# THA Architects, LLC

Re: Plan Examination  
Midtown Building 2 – 8 Story Parking structure with Mixed use space  
59 Somerset Street  
Portland, ME 04101

We are in receipt of your plan examination for the Midtown Building 2 – 8 Story Parking structure with Mixed use space dated 2/20/2018 for a project located at 59 Somerset Street in Portland, ME and we offer to you the following responses. Feel free to contact me if you have any questions.

SHEET NUMBER
A-6.1

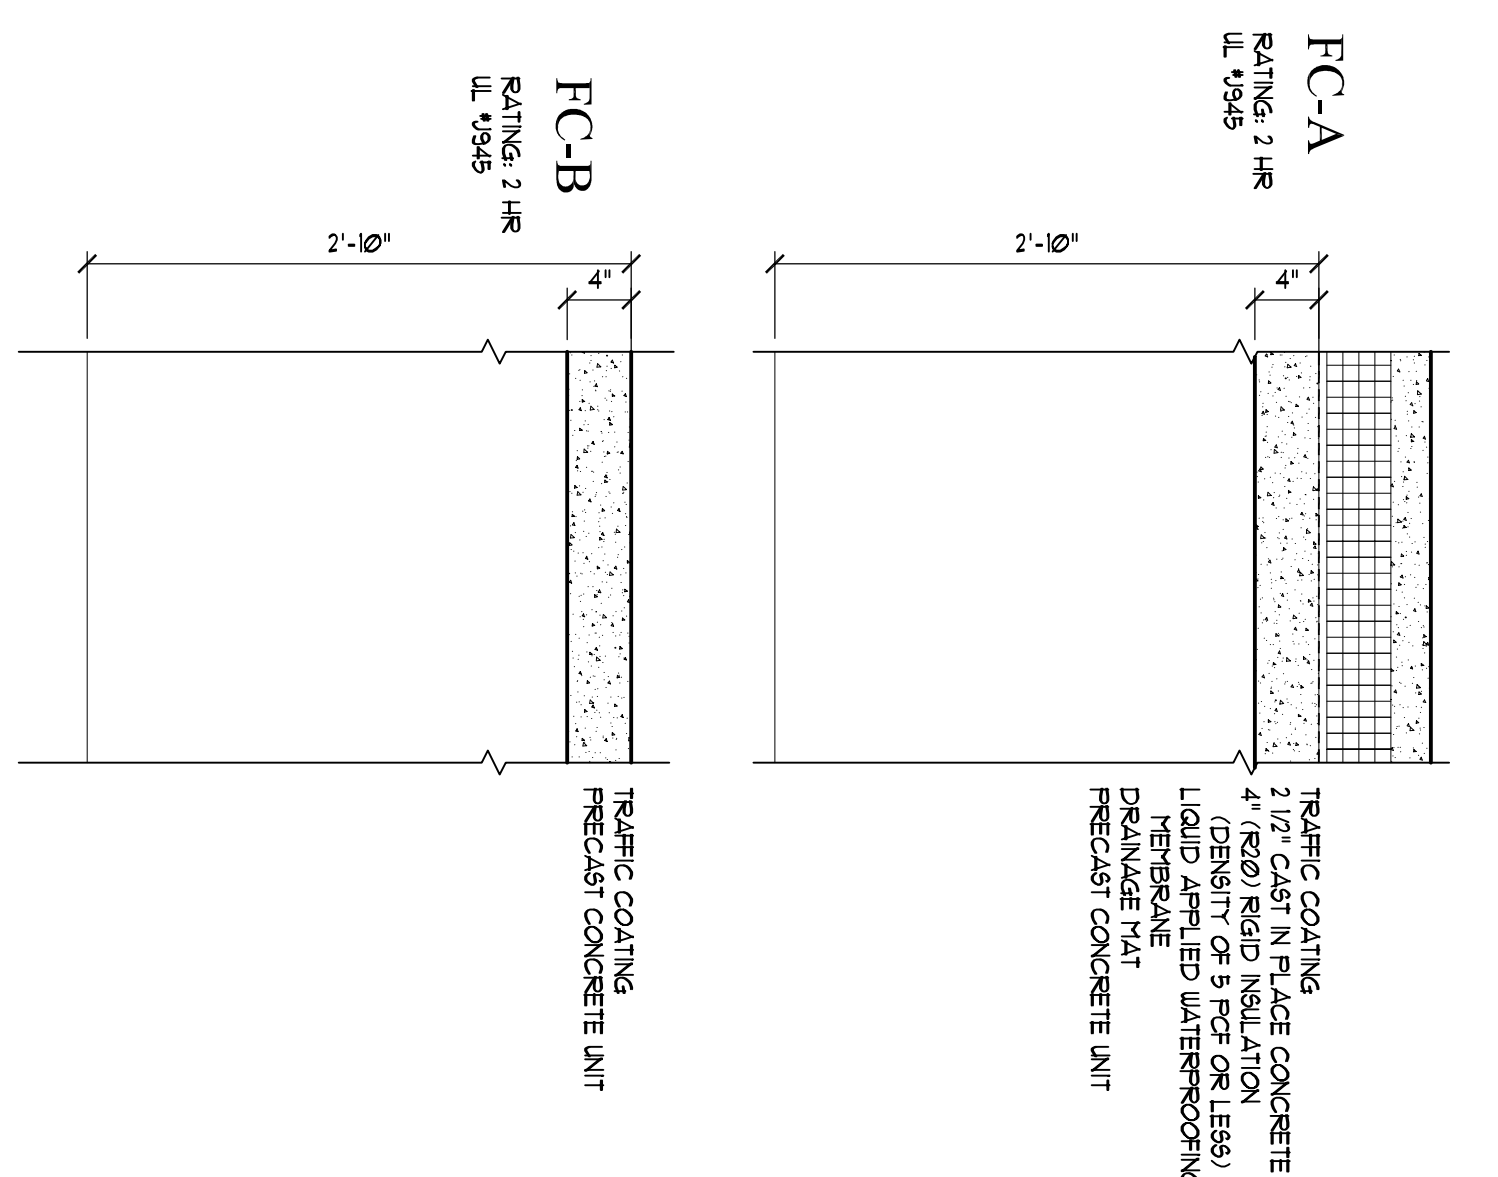
- Sheet A-2.1a dated June 2, 2016 indicates that a 15-minute thermal barrier is to be provided over spray foam insulation. The note on sheet A-2.1a also indicates that the spray foam is sprayed over the sloped concrete ramp and not the precast deck above. The insulation value shown should read “R-20” and not “R-25”. This is a scrivener’s error. The thermal barrier material is shown on sheet A-0.2 dated June 2, 2016 within the outline specifications under Section 7, paragraph G. The spray foam insulation material has been added to sheet A-0.2 dated March 2, 2018 within the outline specifications under Section 7, paragraph B. In addition, sheet A-6.1 dated March 2, 2018 has been revised to add the Floor/Ceiling assembly (FC-C) for under the ramp for clarity. It should be noted that within the Bicycle Storage Room there are wide flanged beams. The spray on insulation will be applied to the steel and then the ¾” furring channels and ½” gypsum wallboard will be applied, hence a deeper floor/ceiling assembly dimension as described in the calculation sheet
